**M1 Pacific Motorway extension to Raymond Terrace (SSI 7319)
Advice on the Environmental Impact Statement (EIS)**

Thank you for the request for advice from Public Authority Consultation (PAE-24749572), requesting the review by the NSW Environment Protection Authority (EPA) of the Environmental Impact Statement (EIS) for the proposed M1 Pacific Motorway extension to Raymond Terrace (Application SSI-7319).

ATTACHMENT A: EPA COMMENT ON EIS FOR M1 PACIFIC MOTORWAY EXTENSION TO RAYMOND TERRACE (SSI 7319)

B.2 Long term noise monitoring results

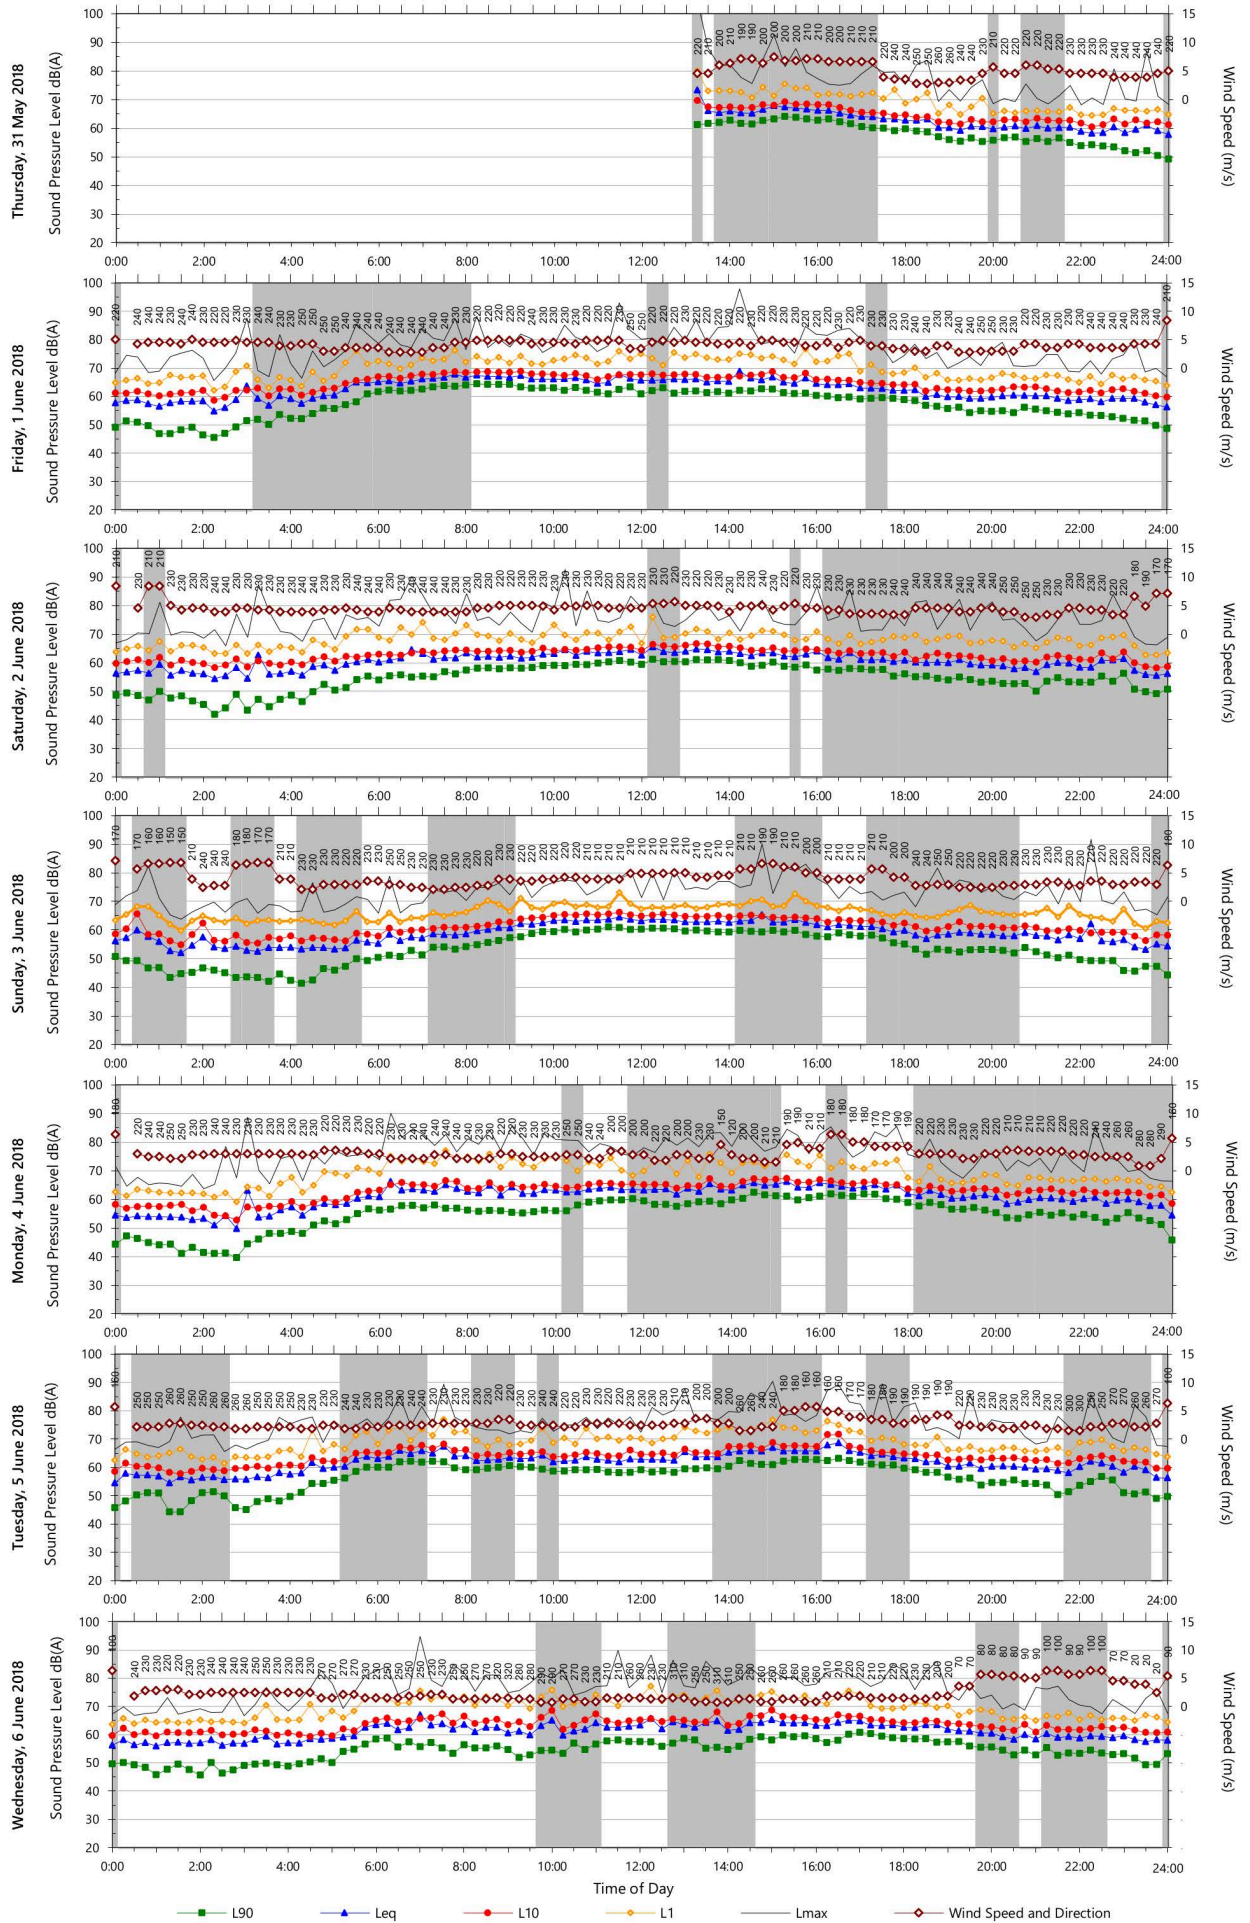
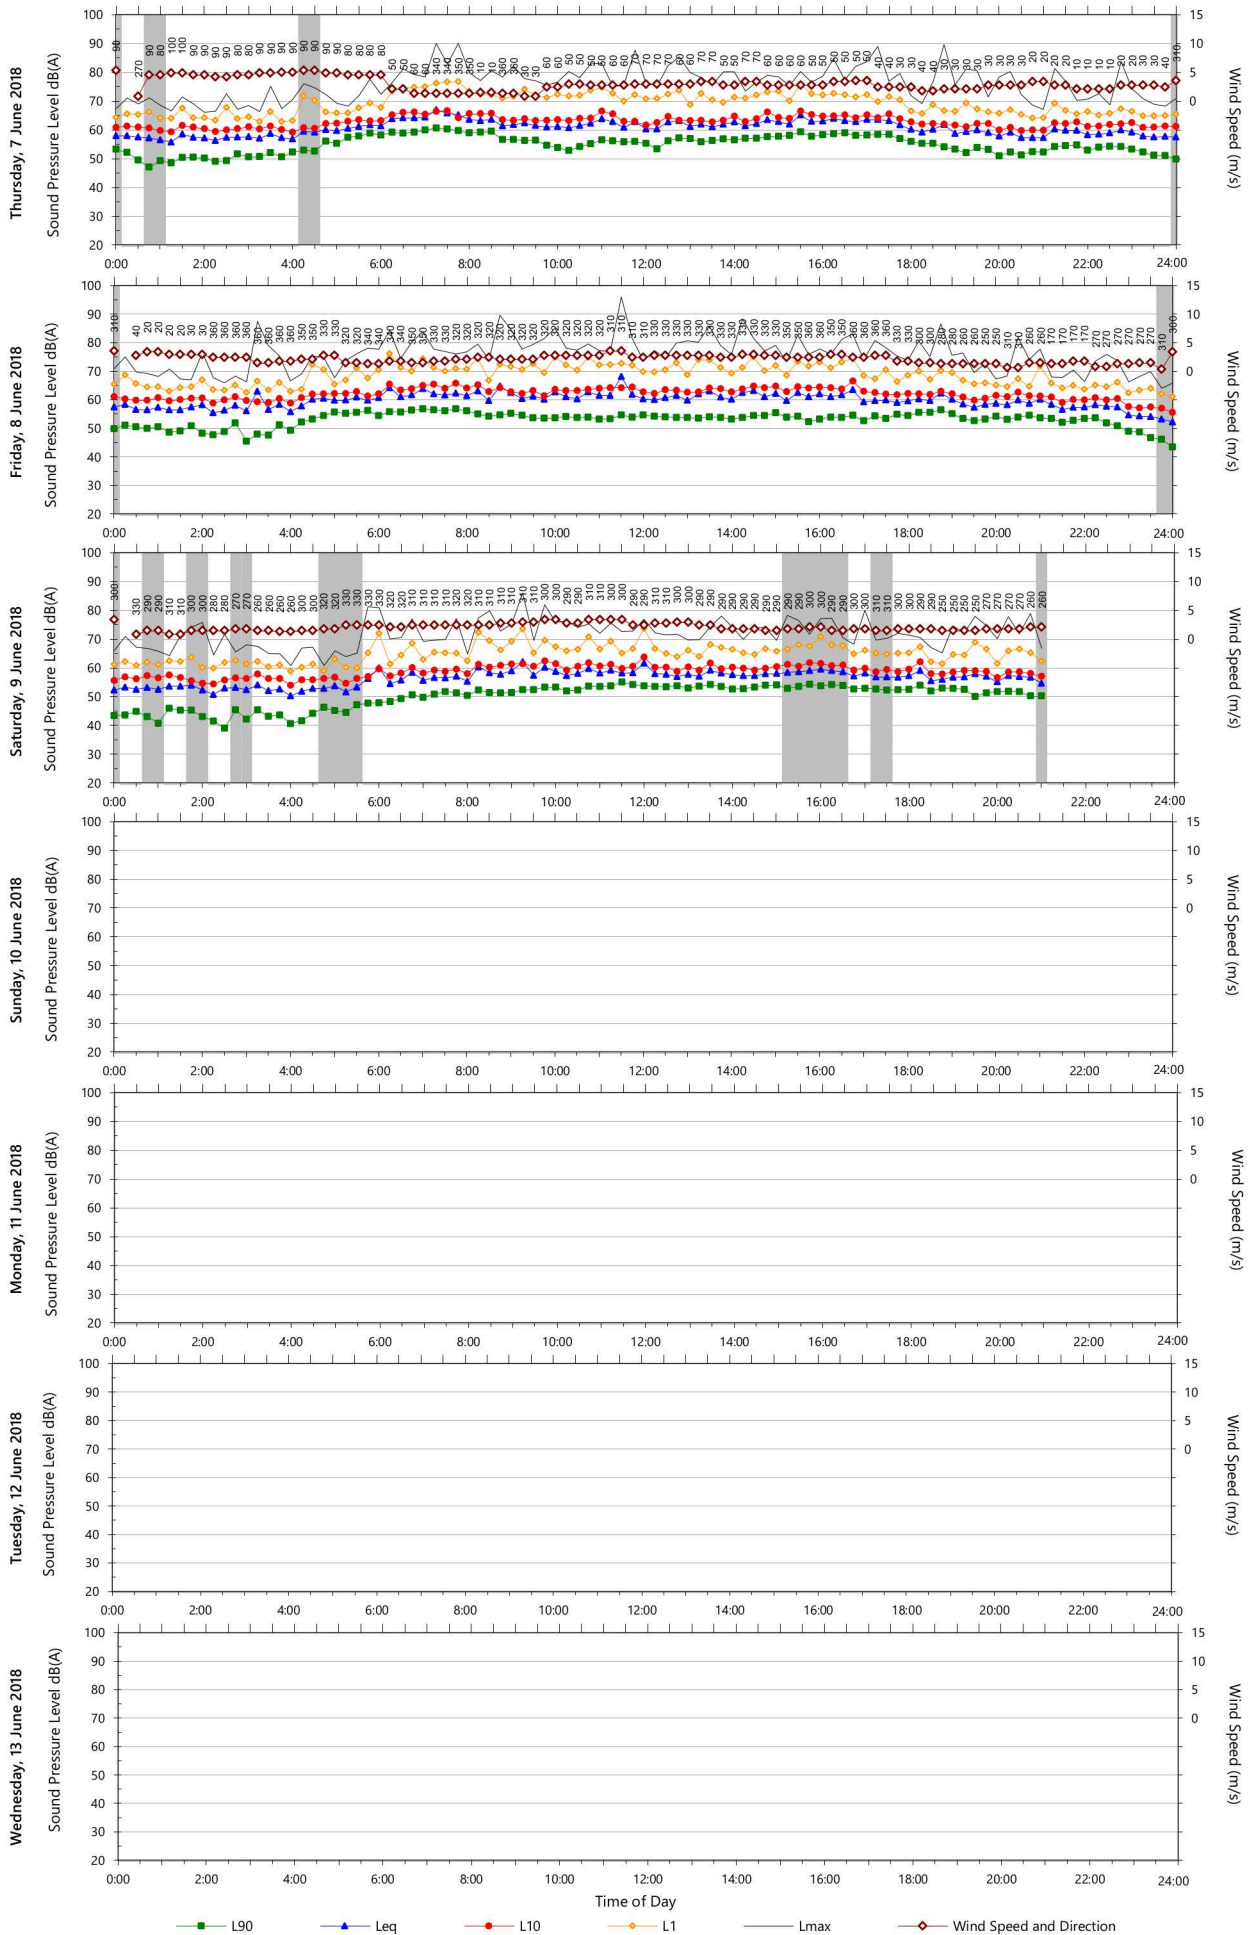
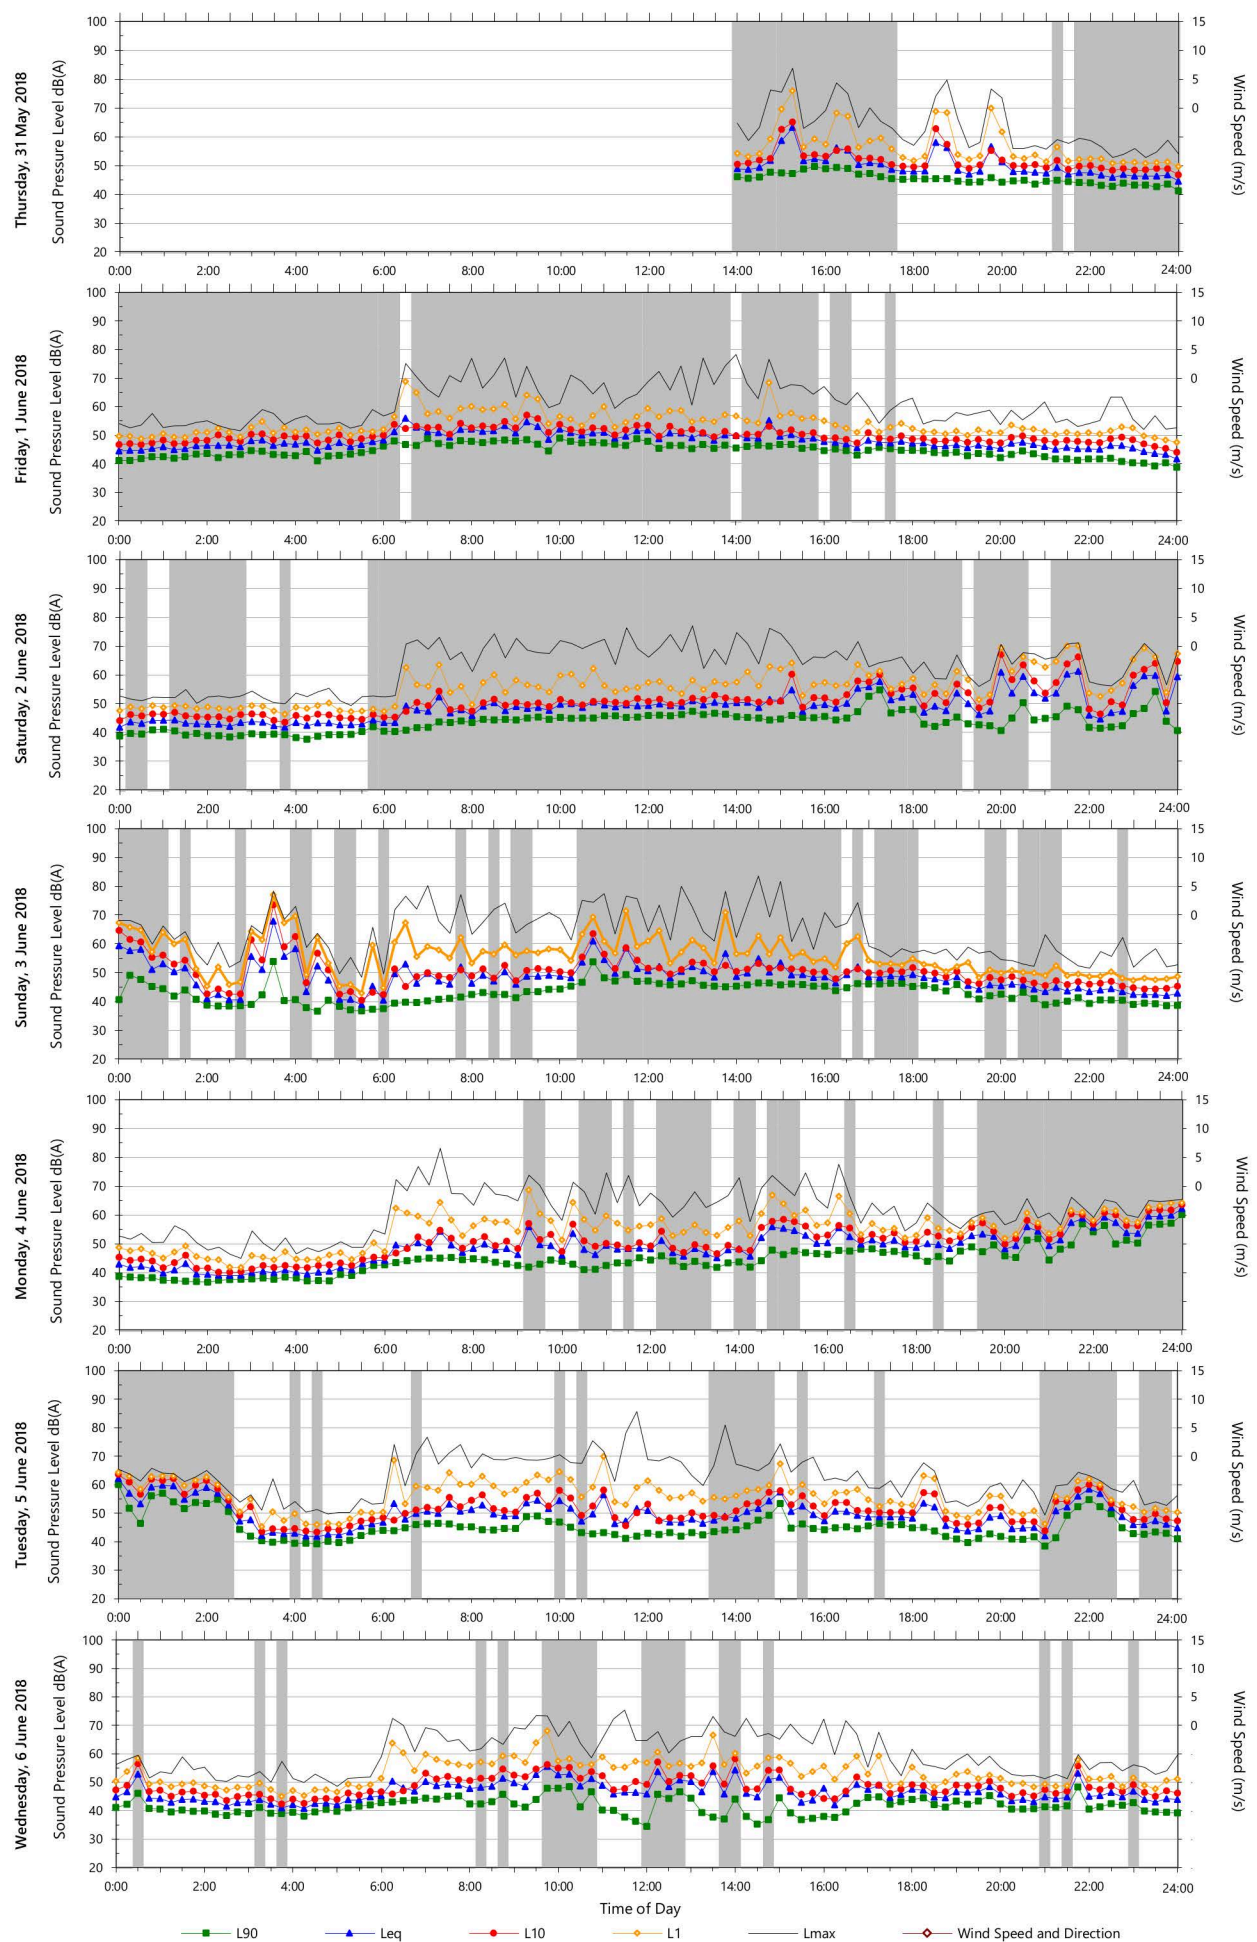
A review of the noise monitoring graphs in NIA Appendix B.2 indicates that further justification for the adequacy of noise monitoring presented or additional information is required.

A significant amount of data appears to have been excluded due to either inclement weather or extraneous noise. The EPA is concerned that the extent of data excluded means that it may not be representative of long term background noise levels, and therefore its suitability to be used to establish reliable noise management levels could be called into question.

Locations L01 to L014 (inclusive) appear to have no more than 5 and in some cases less than 3 valid periods out of the total monitoring duration. Locations L15 to L20 appear to be less affected, however there it is still not clear if sufficient valid data has been presented.

Fact Sheets A and B in the Noise Policy for Industry (NPfI) set out the EPA's requirements for establishing background noise levels. Due to the amount of data excluded, it is currently not clear if these requirements have been satisfied nor if sufficient valid data has been presented in order to establish representative background noise levels.

Noise monitoring was also conducted in 2016 for the purposes of measuring road traffic noise. Due to the amount of data excluded at Locations L13 to L20, further justification is needed that the remaining data, after invalid samples were excluded, provides sufficient amount of data to enable a representative calculation of the traffic noise descriptors.

The proponent reviews the noise monitoring data in the NIA in the context of the monitoring requirements set out in the NPfI and for each location and either:

- Provide a justification and demonstrate that the requirements of the NPfl have been fulfilled; or
- Provide additional data that fulfills the monitoring requirements in the NPfl.

The EPA also recommends that the proponent either:

- Provides justification and demonstrate that the data presented for road traffic noise descriptors is sufficient to be representative; or
- Provides additional valid data.
